**A122 LOWER THAMES CROSSING (REF: TR010032)
DEADLINE 6 WRITTEN REPRESENTATIONS**

MELVILLE HAMILTON LOWE MOTT – AFFECTED PARTY REFERENCE: AP1308

C H L MOTT & M MOTT – AFFECTED PARTY REFERENCE: AP1369

On behalf of our above clients, the Mott family, we write further to Compulsory Acquisition Hearing 3 ('CAH3') held on 17 October 2023 with our written submissions in support of the oral representations made at that hearing.

Plate 8

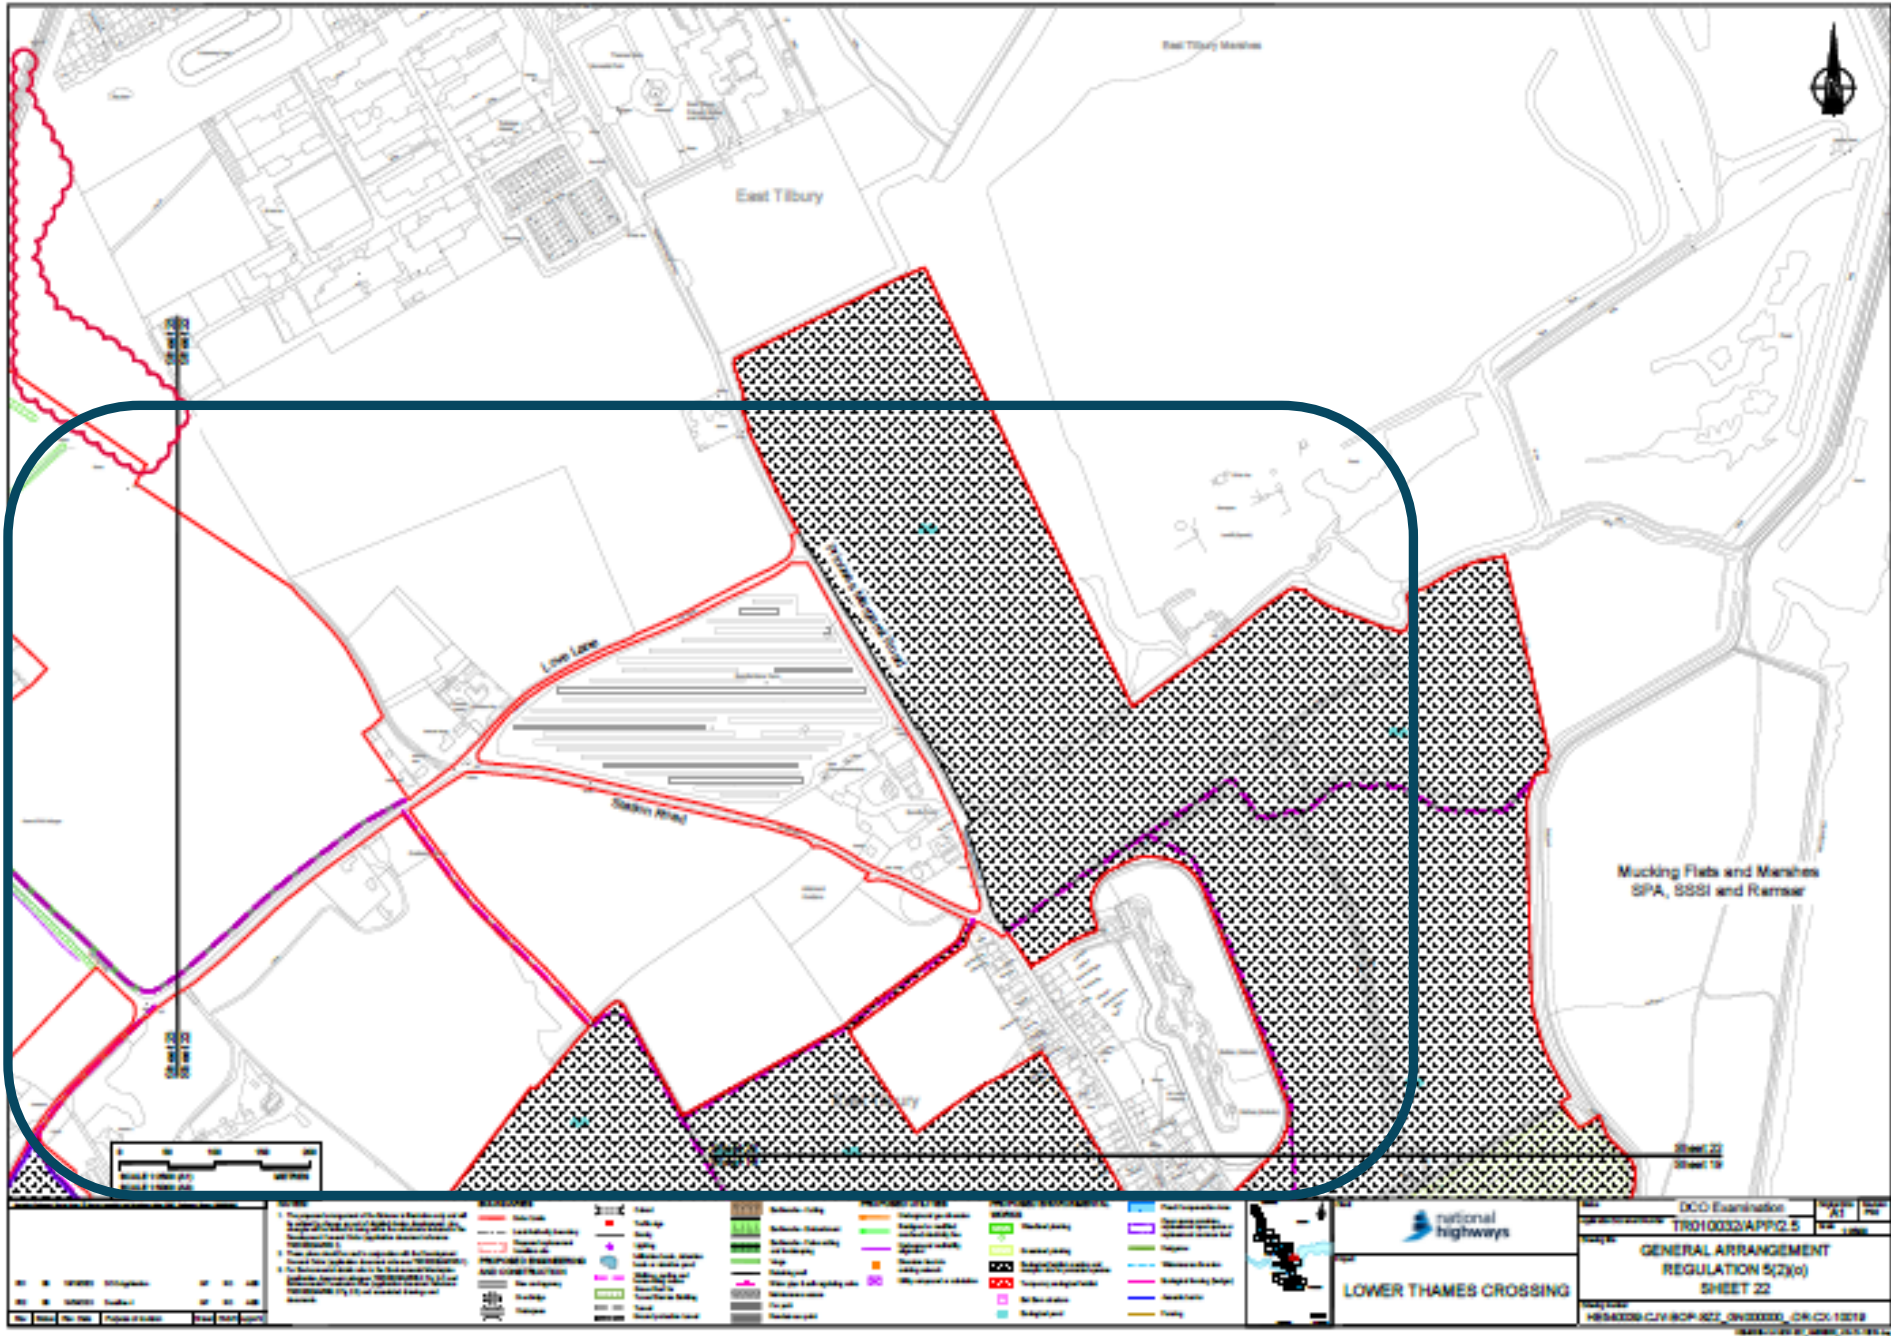
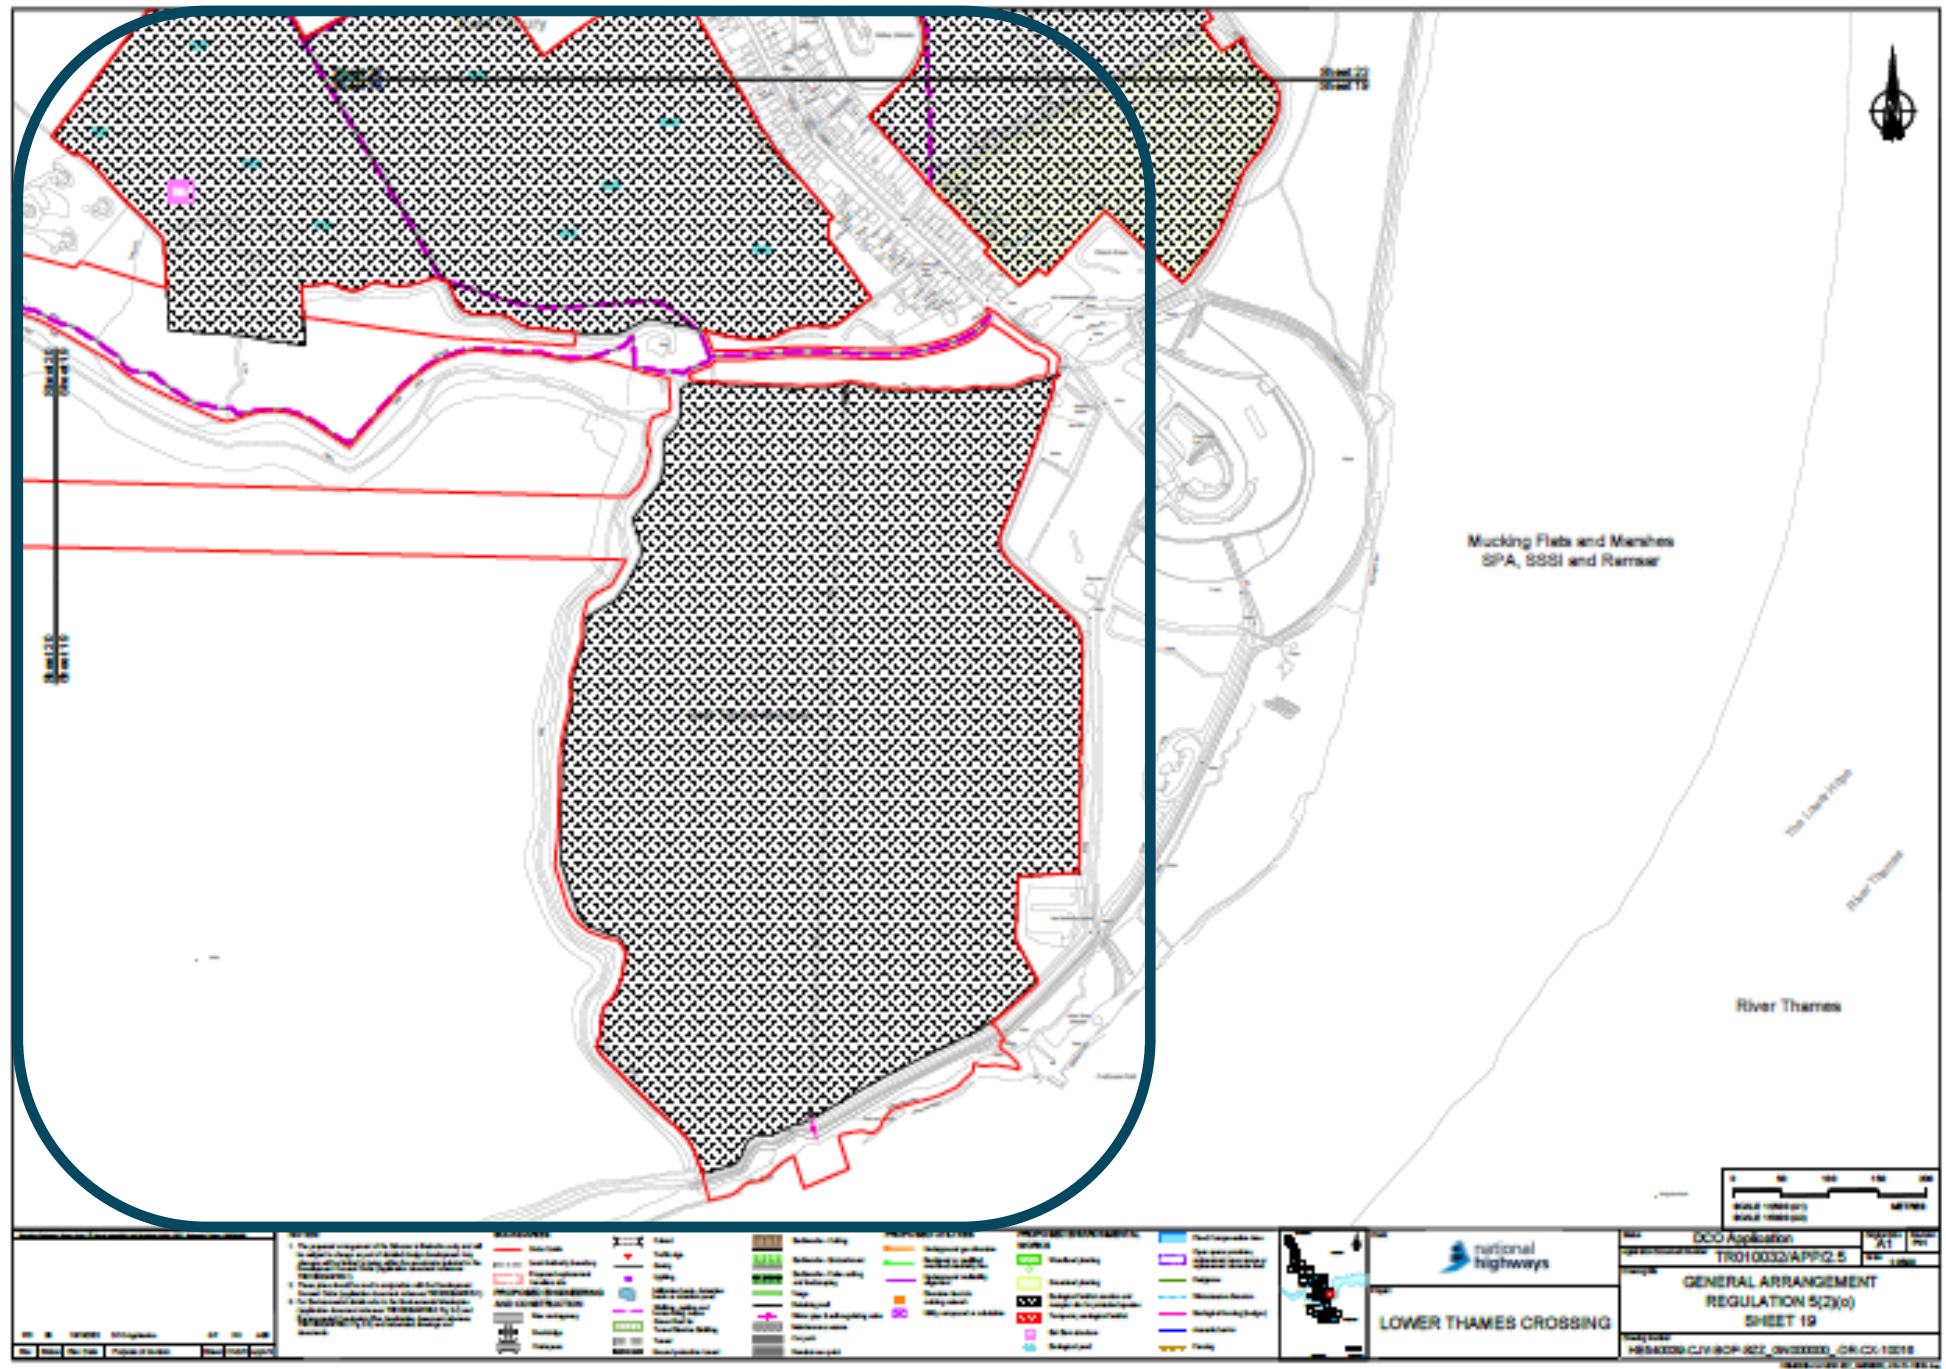
Plates 3 to 7	Plates 3 to 7 show extracts from the Applicant's Land Use Plans at REP5-006 and REP5-008 (sheets 16, 19, 20, 22 and 23) with the Mott Family's ownership comprised within the areas in the blue boxes.
ISSUE	
Ecological Mitigation Land- Extent	<p>Plates 8 & 9 – show the areas of Open Mosaic Habitat proposed by the Applicant within the blue box.</p> <p>Plate 9 - shows the area of Coalhouse Point Wetland Habitat proposed by the Applicant within the blue box</p> <p>Plates 10, 11 & 12 – shows the area referred to as Tilbury Fields and around the northern portal (open mosaic habitat) within the blue box as proposed by the Applicant.</p> <p>In total, the land area proposed to be permanently acquired for these purposes from our client equates to 264 acres or thereabouts.</p> <p>Further to our representations at Deadline 1 REP1-319 & 320 and Deadline 2 REP2-096 our submissions in respect of the Ecological Mitigation Land proposals are as follows:</p> <ol style="list-style-type: none"> 1) In the Applicant's response under 'Compensation Land (Generally) contained in the draft SOCG REP4-205 between the Applicant and the Mott Family, the Applicant refers to its preference to engage a 'competent authority' e.g. a local authority or similar body who has an established track record of maintaining such habitats. 2) It further states that this assists with compliance risks. 3) The Mott family have managed this land for the over 100 years. 4) They have the labour and machinery and skill set to manage land for a variety of uses and also are engaged in managing land under a new Countryside Stewardship Scheme across their holding. 5) To consider a local authority or similar body as the only competent authorities to manage land for ecological purposes is short sighted and fails to recognise the value that existing landowners who understand this land bring to that arrangement.

Plate 14

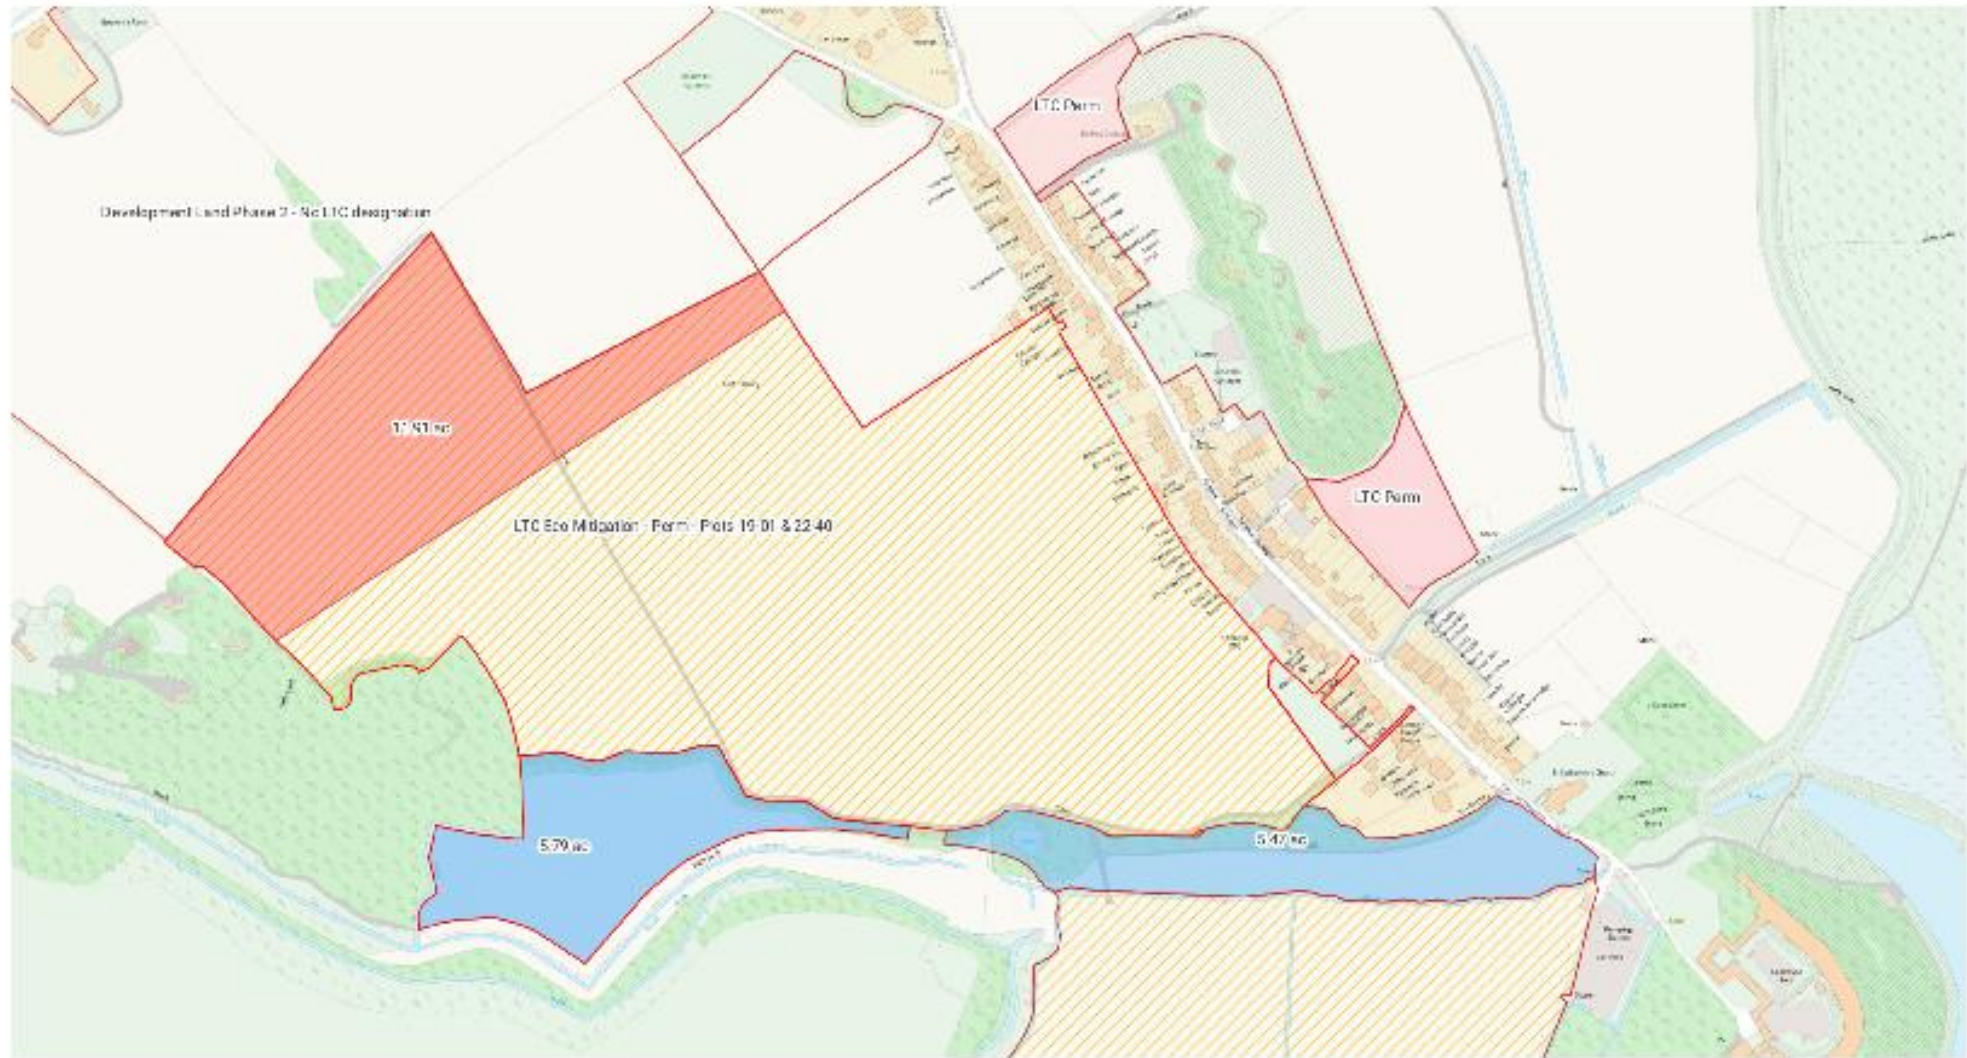
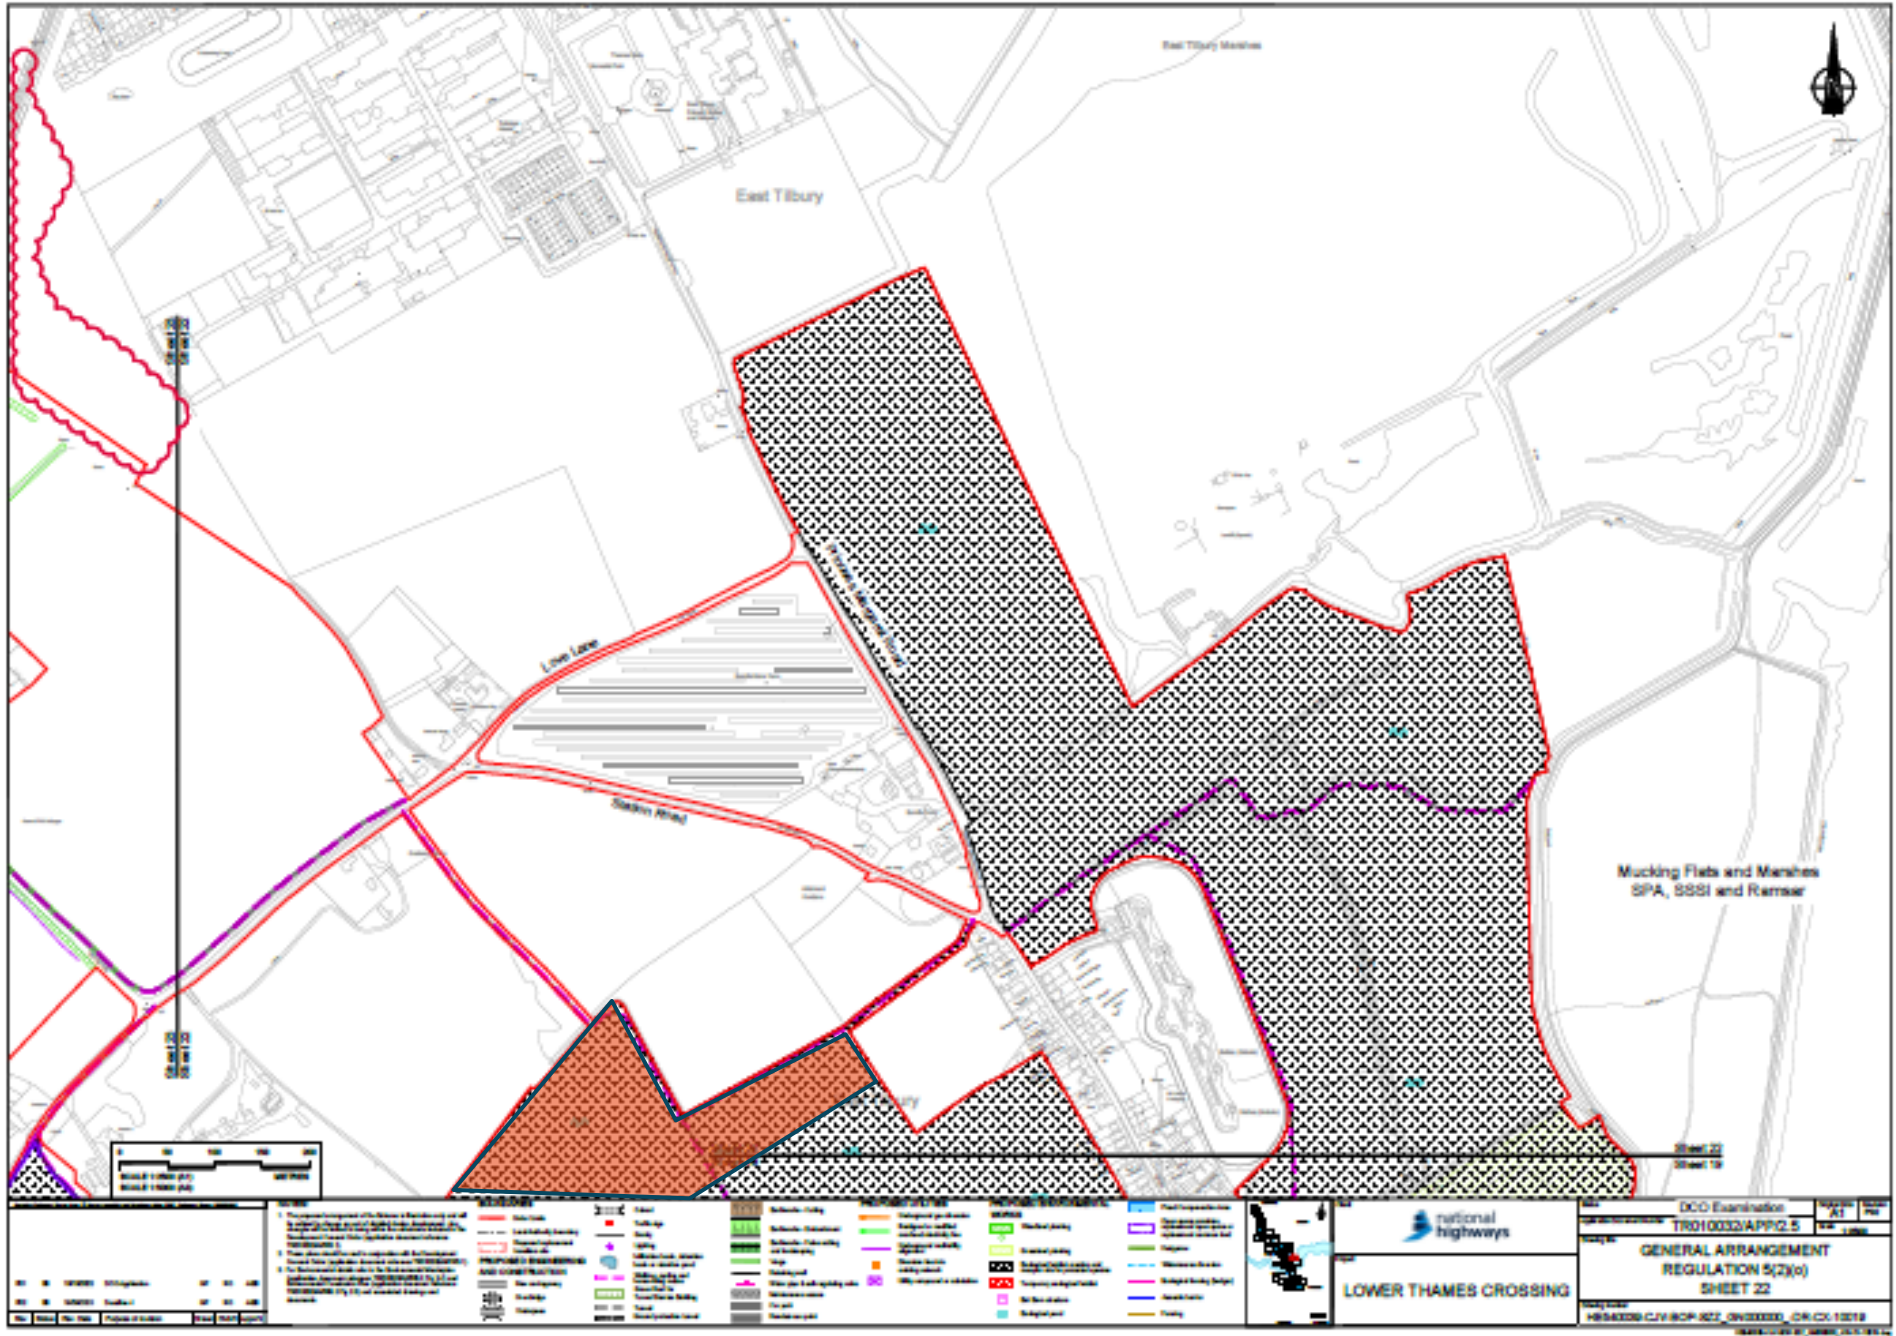
<p>Ecological Mitigation Land - Land Swap</p>	<p>Plates 13, 14 & 15 - show the proposed land swap as submitted under Deadline 3 - REP3-174</p> <p>It shows two areas of arable land of approx. 5.79 acres and 5.47 acres shaded blue in exchange for the removal of an area of arable land shaded orange 11.91 acres (which also forms the upper part of Area 1B of the Mulberry Strategic Land land capacity study area (as shown on Plate 2) from the Applicant's proposals.</p> <p>In order to mitigate 1) loss of farmland and 2) loss of future development land, our submissions are as follows (and with reference to our Deadline 3 submissions):</p> <p>1) Amendment to mitigation boundaries as proposed by our client;</p>

<p>2) To provide for a commitment to include drainage route through blue land to serve retained land to north - whether or not the mitigation boundaries are amended. The natural drainage point will require rights to be reserved over any land acquired by the Applicant of land immediately west of East Tilbury.</p>
<p>Northern Portal Access Track</p>	<p>Plate 16 - General Layout</p> <p>Plate 17 - Land Plan showing permanent acquisition of route</p> <p>Plate 18 - route of haul road under MUT4</p> <p>Plate 19 - route of MUT4 and MUT27</p> <p>In this respect please also refer to our submission under Deadline 1 REP1 - 320 - section 4.</p> <p>Our submissions are as follows:</p> <ol style="list-style-type: none"> 1) We consider that there is an alternative means of providing legal rights for the Applicant's proposed use and future maintenance responsibilities without the need for freehold acquisition of the route and our client objects to the proposed permanent acquisition. 2) If rights for permanent acquisition are granted, without prejudice to our client's objection, we consider that our client should be granted the right to any future uplift in value that may be associated with the use of this route as a potential link road to adjoining land for any purpose outside of the consented Lower Thames Crossing project. 3) In either scenario, on the basis that the Applicant has provided for a right of access for our client to their retained land under the Stakeholder Actions and Commitments Register ('SACR') SACR-006 that a technical working group is formed to include our client to agree the construction specification of this route.
